**SDRP #3 Response**

State Significant Development SSD-17424905  
 Pymble Ladies College – Grey House Precinct  
 20 Avon Road, Pymble (Lot 1 DP 69541)

**Table 1 RESPONSE TO SDRP Meeting #3 – 16 March 2022**

1 SHADOW DIAGRAM PROPOSED June 21 - 5PM
1 : 1000

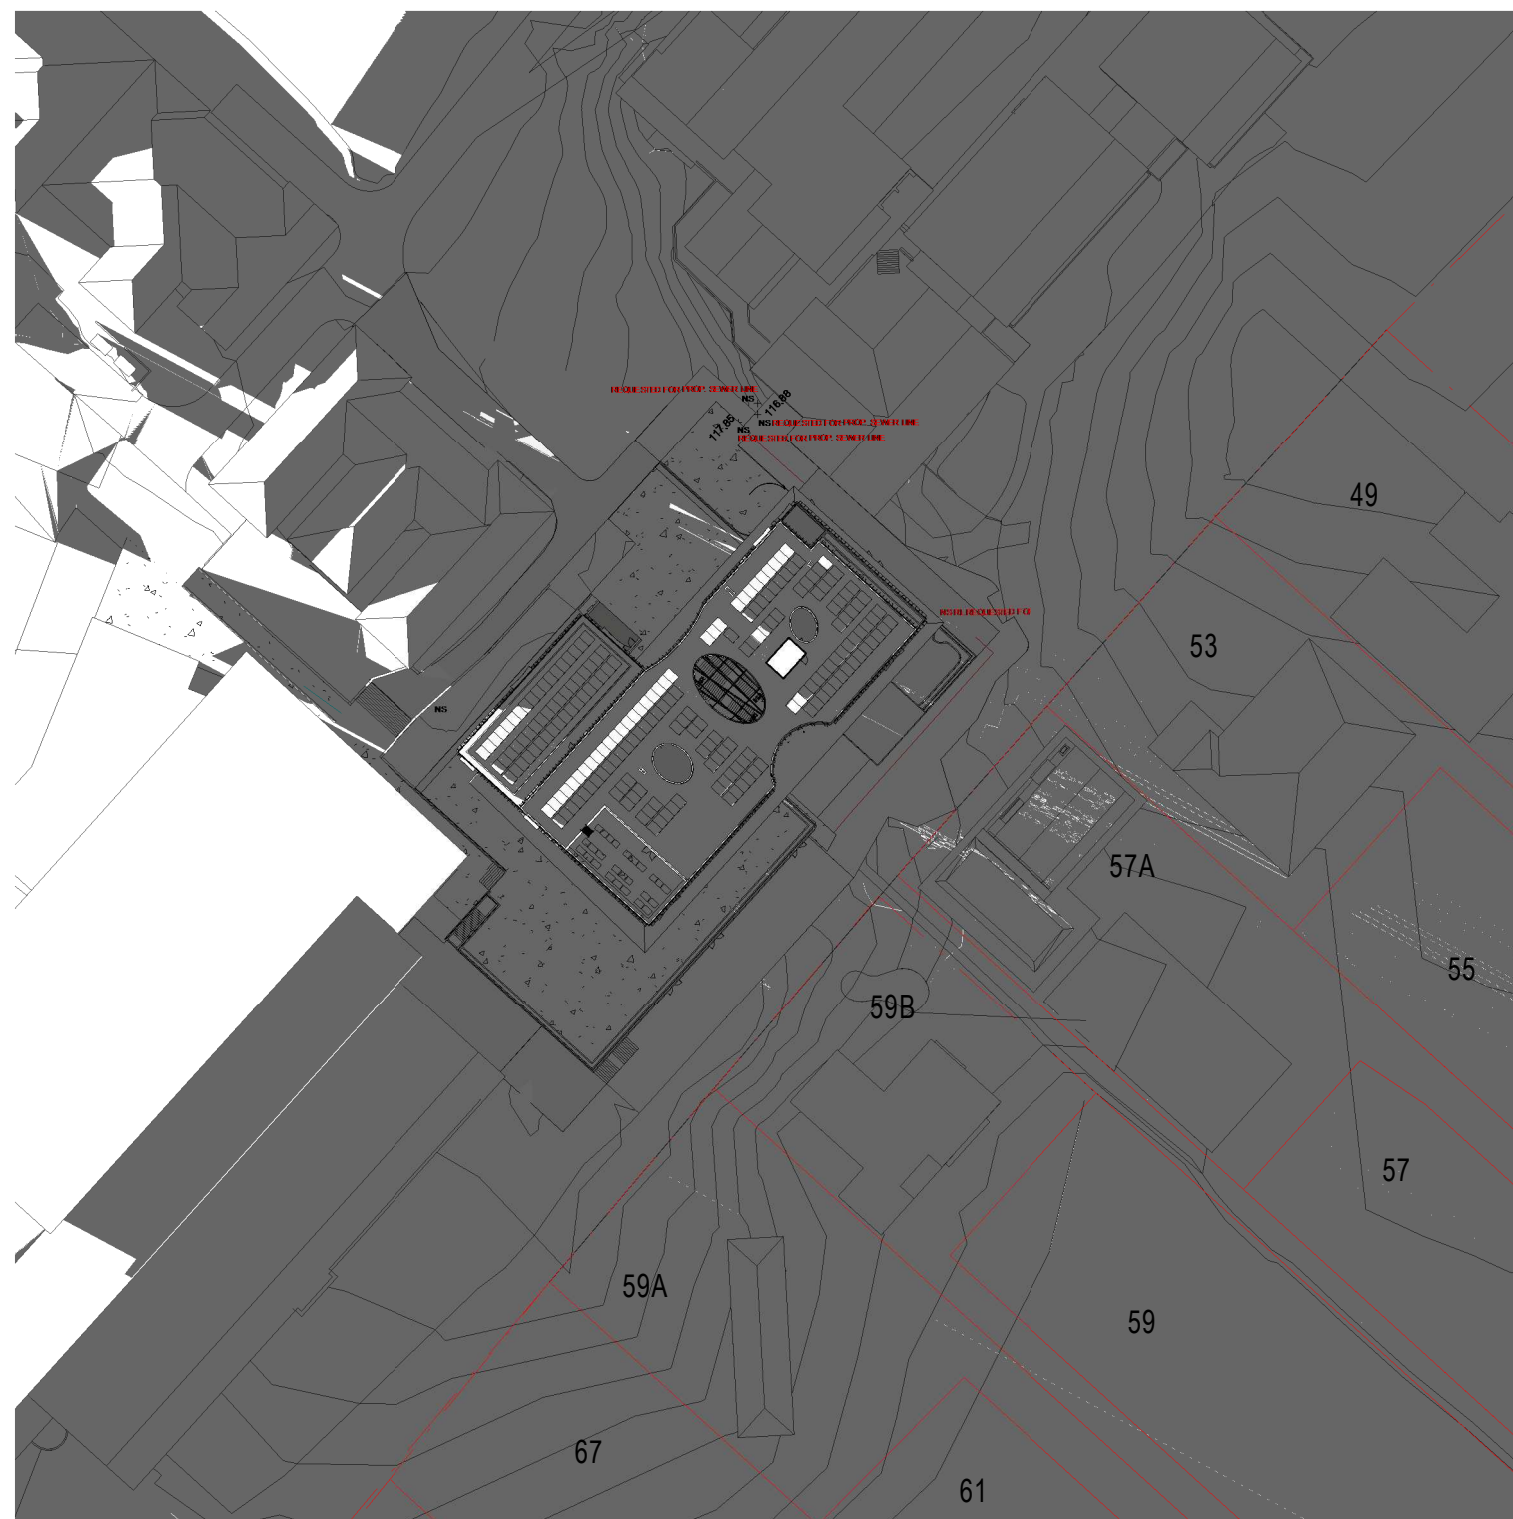
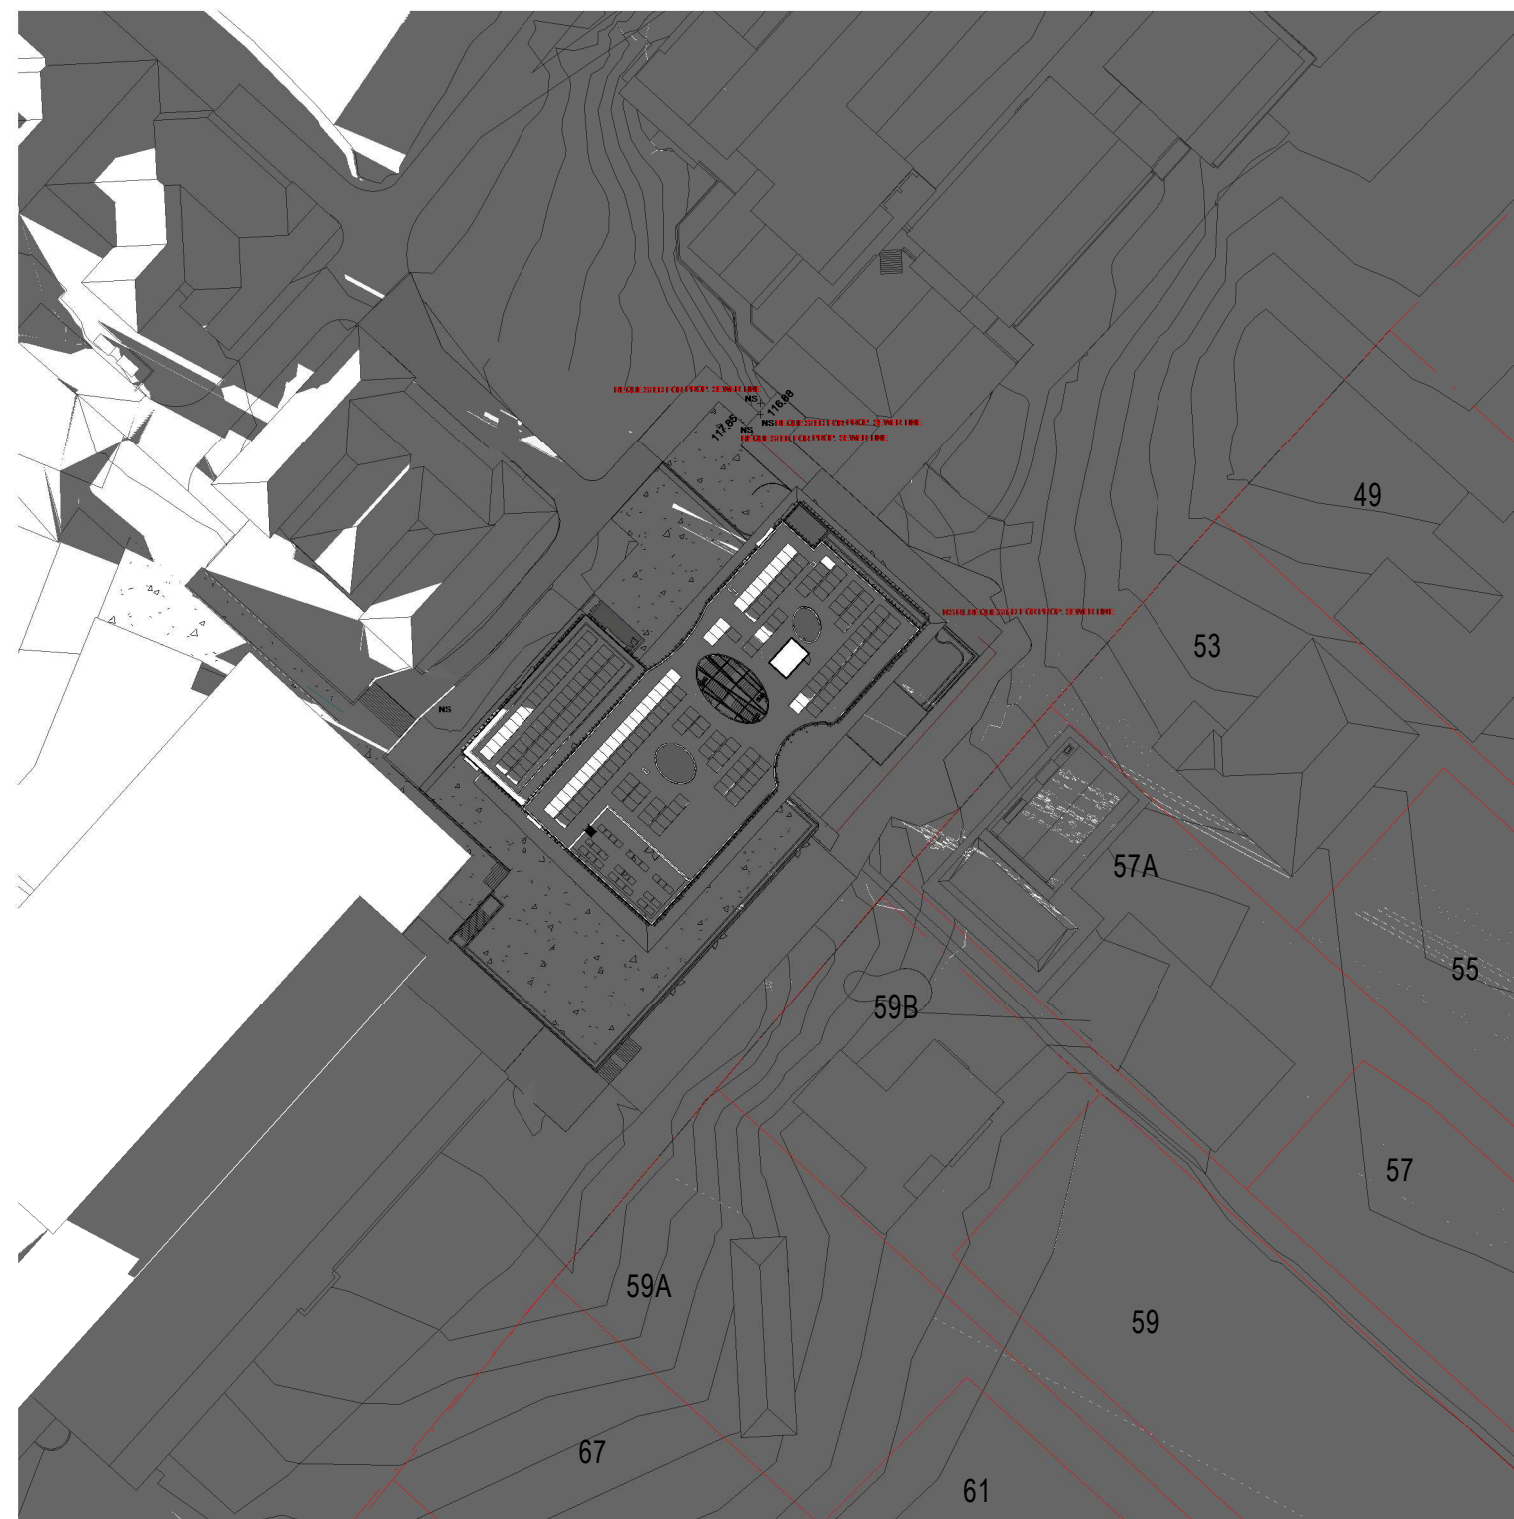
11. Clarify the impact of the proposal on the solar access of the adjoining properties, as this has not been clearly demonstrated. Provide existing and proposed diagrams identifying the quantum of solar access to the living area glazing and the principal private open space of affected properties to demonstrate if a reasonable level of solar access will be maintained for the adjoining properties.	Updated solar diagrams have been included in the Architectural Plans ( <b>Attachment A</b> ) and the Design Report Addendum ( <b>Attachment B</b> ). These clearly demonstrate that there is ample and reasonable solar access to both adjoining residential houses to the south. The private open spaces and internal living spaces of these two dwellings receive at least 3 hours of solar access between 9am-3pm in mid winter with the majority of private open space for each of the dwellings receiving 4 or more hours of solar access. It is considered that there is a reasonable level of solar access maintained to both dwellings.
